CITY OF PORTLAND, MAINE

March 24th, 2016

Project Name: **Construction of new four-unit residential condominium building**
Level III Subdivision and Site Plan
Project #: #2016-005
Address: 31 Fore Street, Portland
CBL: 016 J026001
Applicant: Peninsula Property Development
Planner: Jean Fraser

**BICYCLE HITCH DETAIL**  
NOT TO SCALE

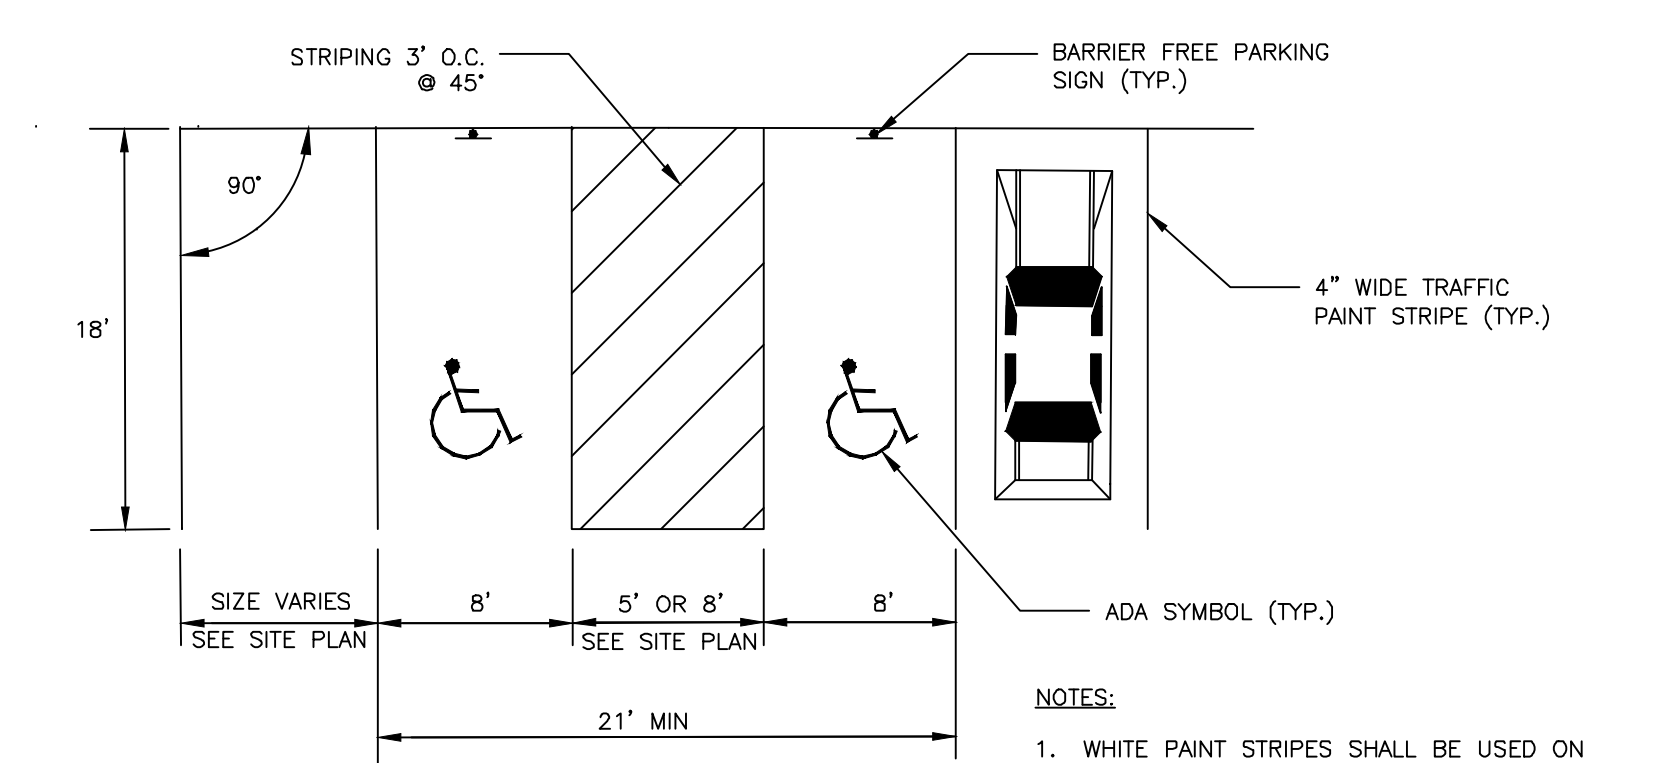
- b. Ensure that the bicycle parking hitches in the ROW are designed to meet the Technical Standards; and
 - c. Show that the design of the balconies will direct drainage and ice/snow so that it will not fall on the sidewalk.

**TREE PROTECTION DETAIL**  
NOT TO SCALE

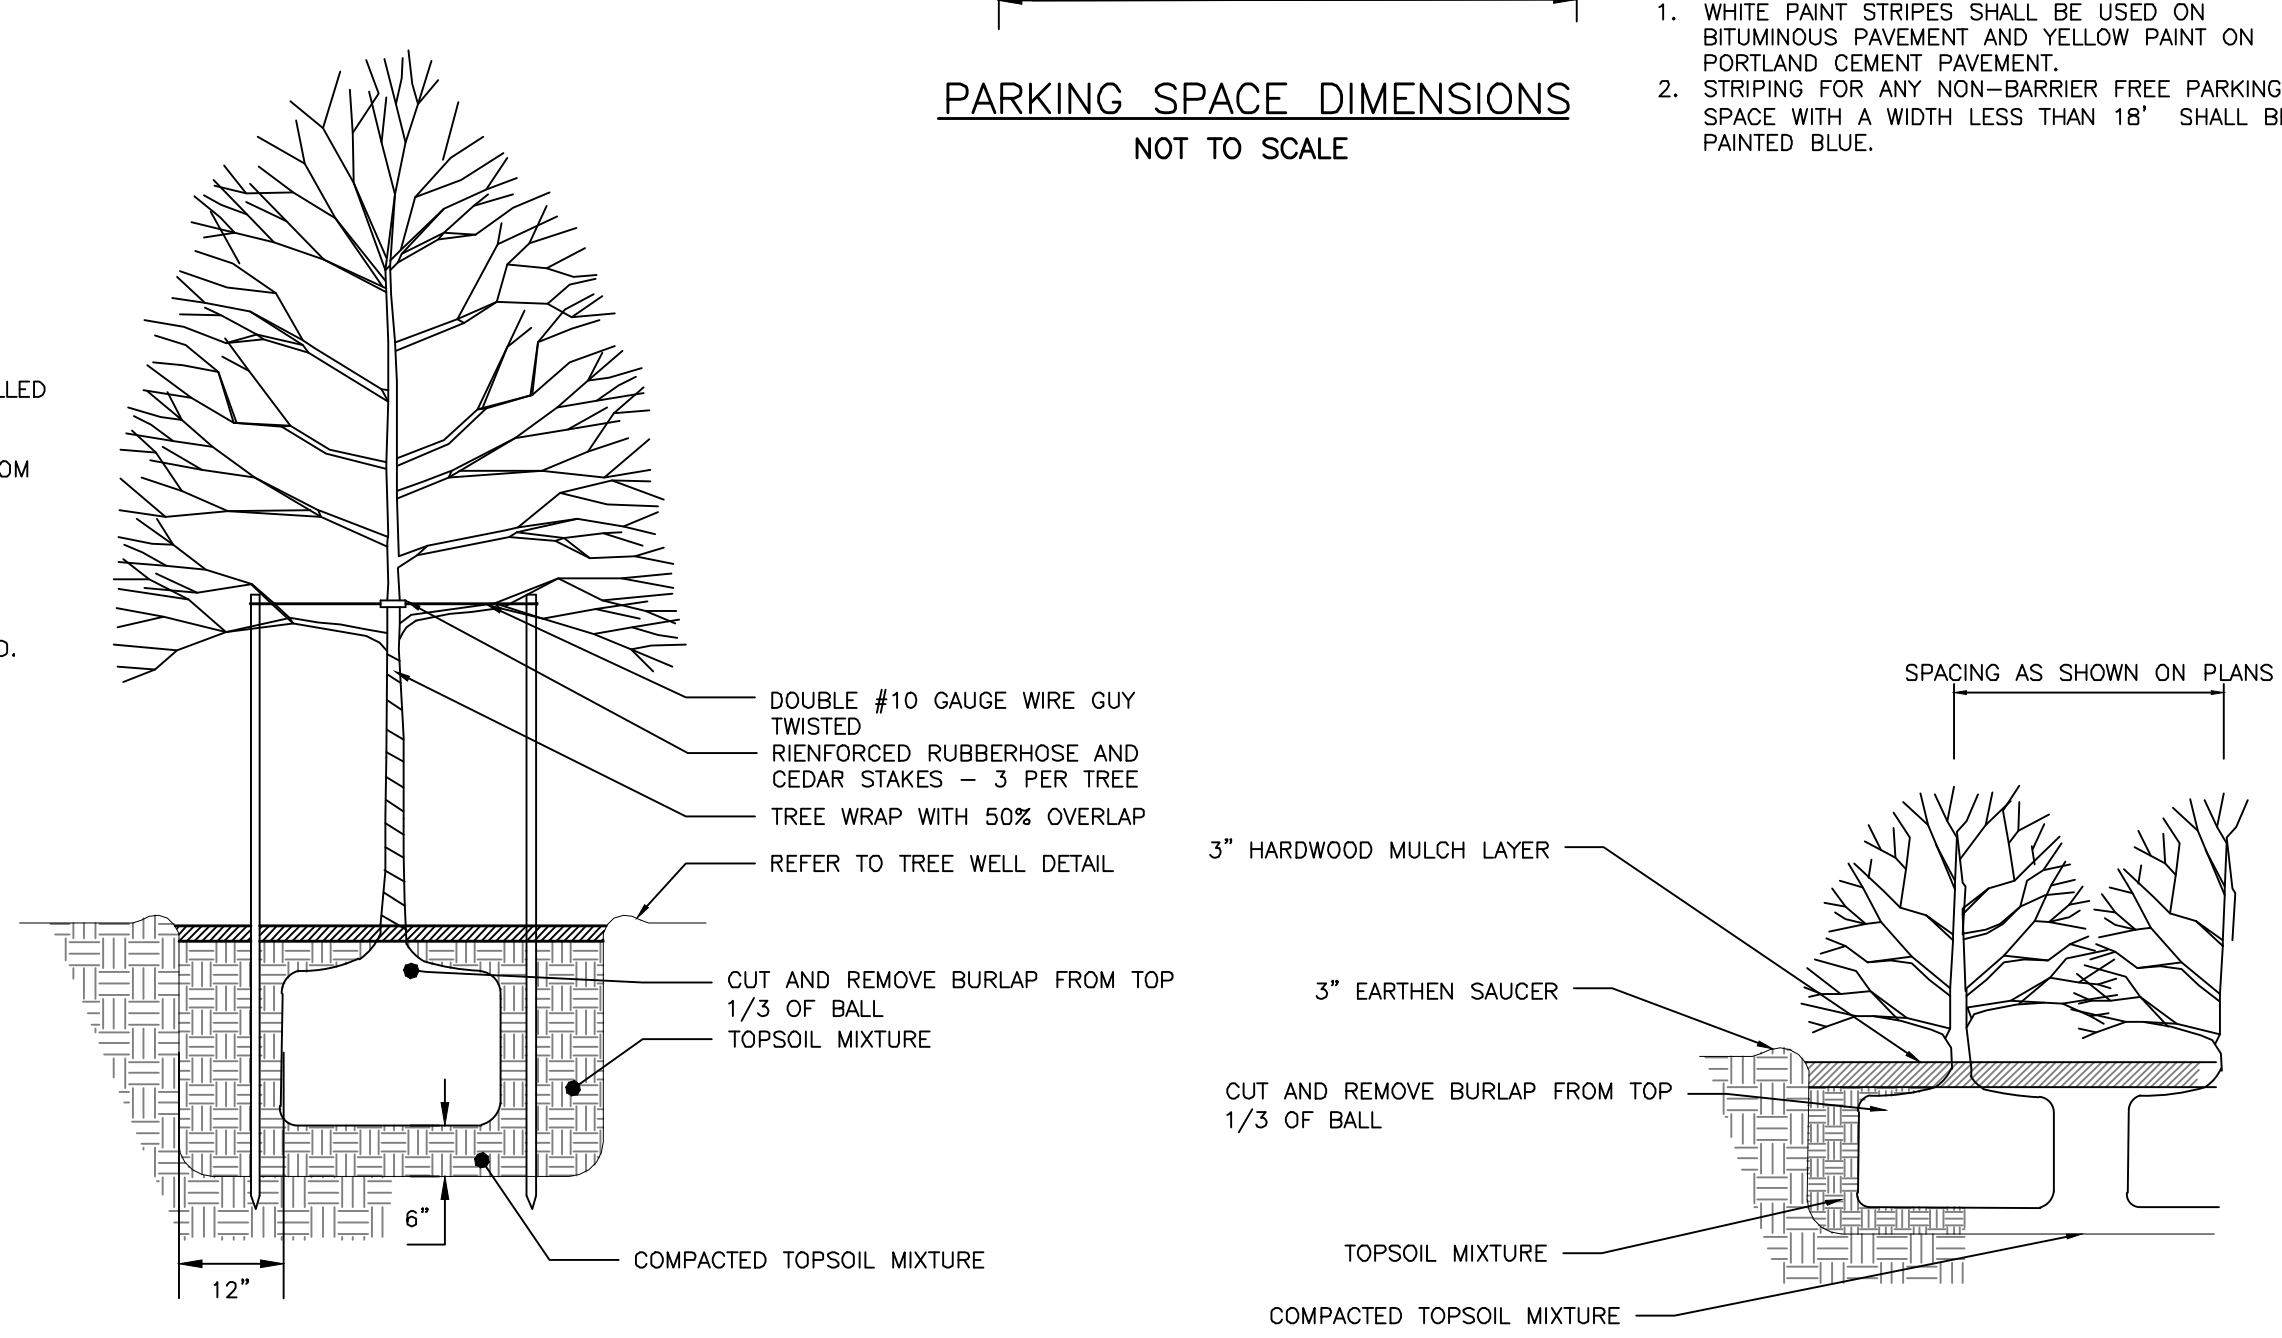
- iv. That the applicant shall take all measures to protect the existing street tree on Fore Street as recommended in the City Arborist comments dated 3.16.2016; and
